Marine Licensing  
Lancaster House  
Newcastle Business Park  
Newcastle upon Tyne  
NE4 7YH

**Your Reference:** TR030003  
**Our Planning Inspectorate  
Reference:** 20010091  
**Our Internal Reference:**  
DCO/2017/00001

30 April 2018

**RE: TILBURY2 – SECTION 89 AND THE INFRASTRUCTURE PLANNING  
(EXAMINATION PROCEDURE) RULES 2010: EXAMINING AUTHORITY’S “RULE 8  
LETTER”**

REVISED SHEET 3 OF THE WORKS
PLANS

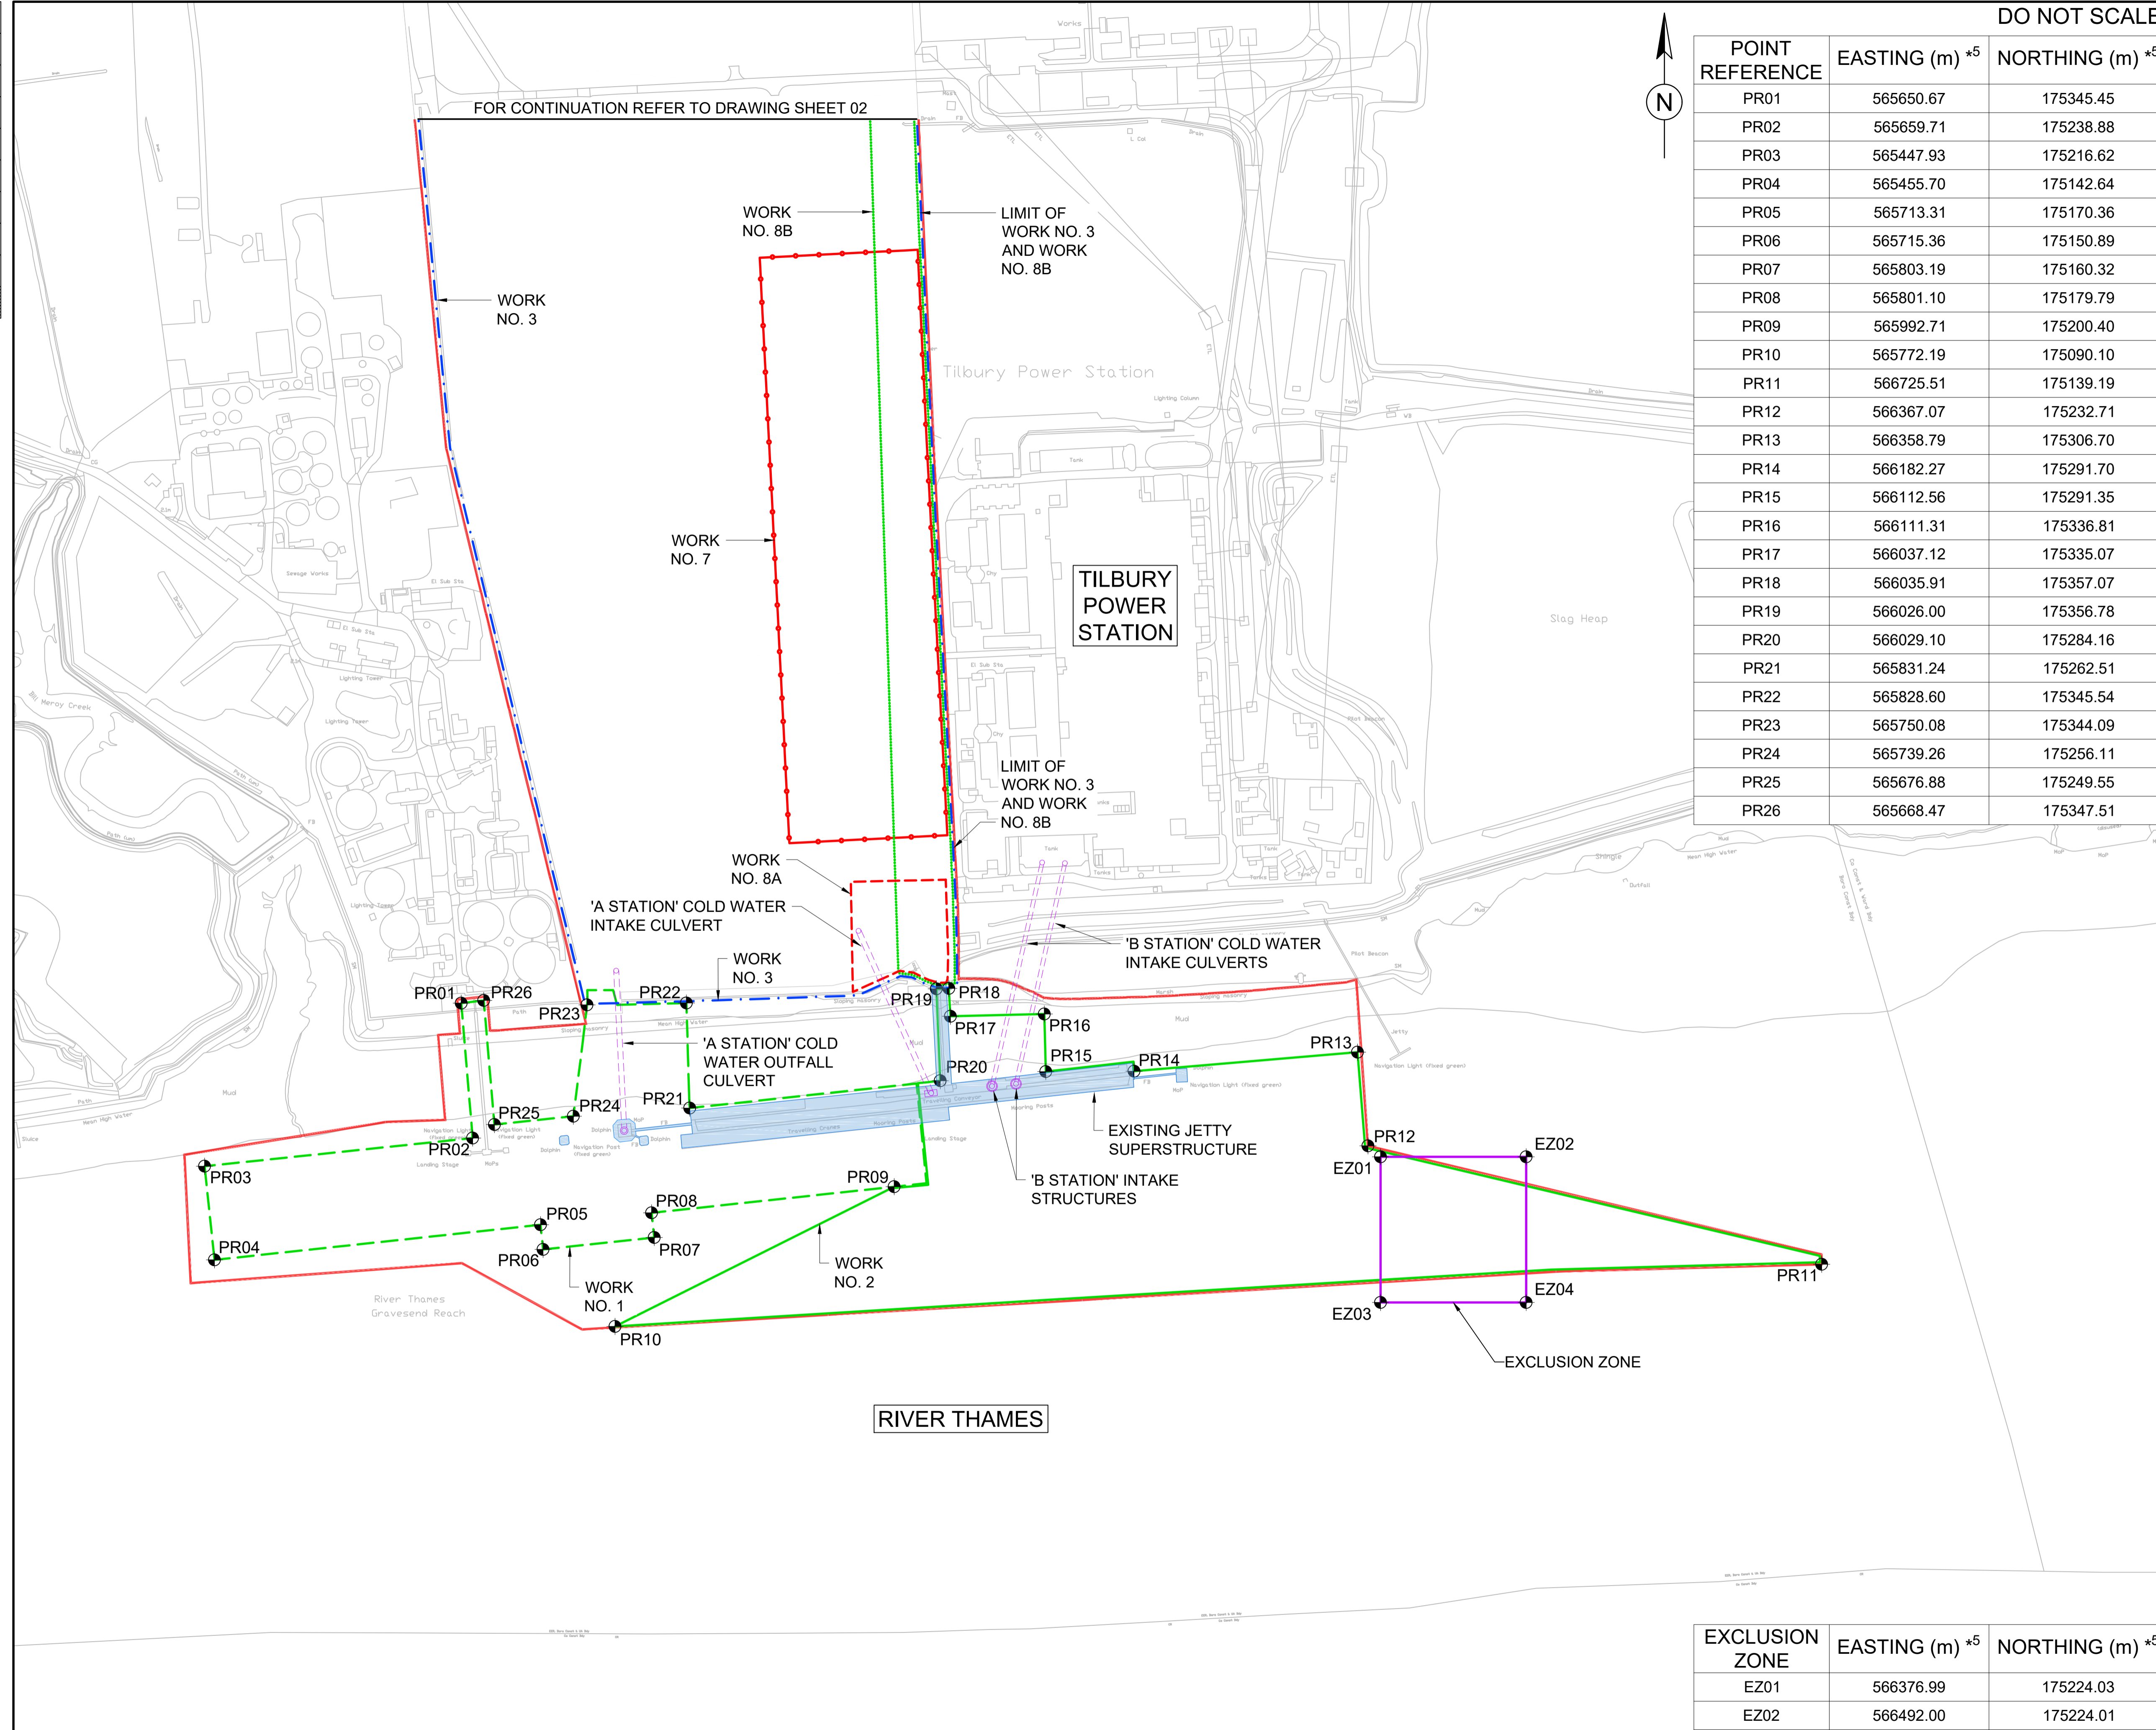
3.4.1. It is the MMO's understanding that this document will be updated to align the boundary of the dredging exclusion zone with the red line boundary.
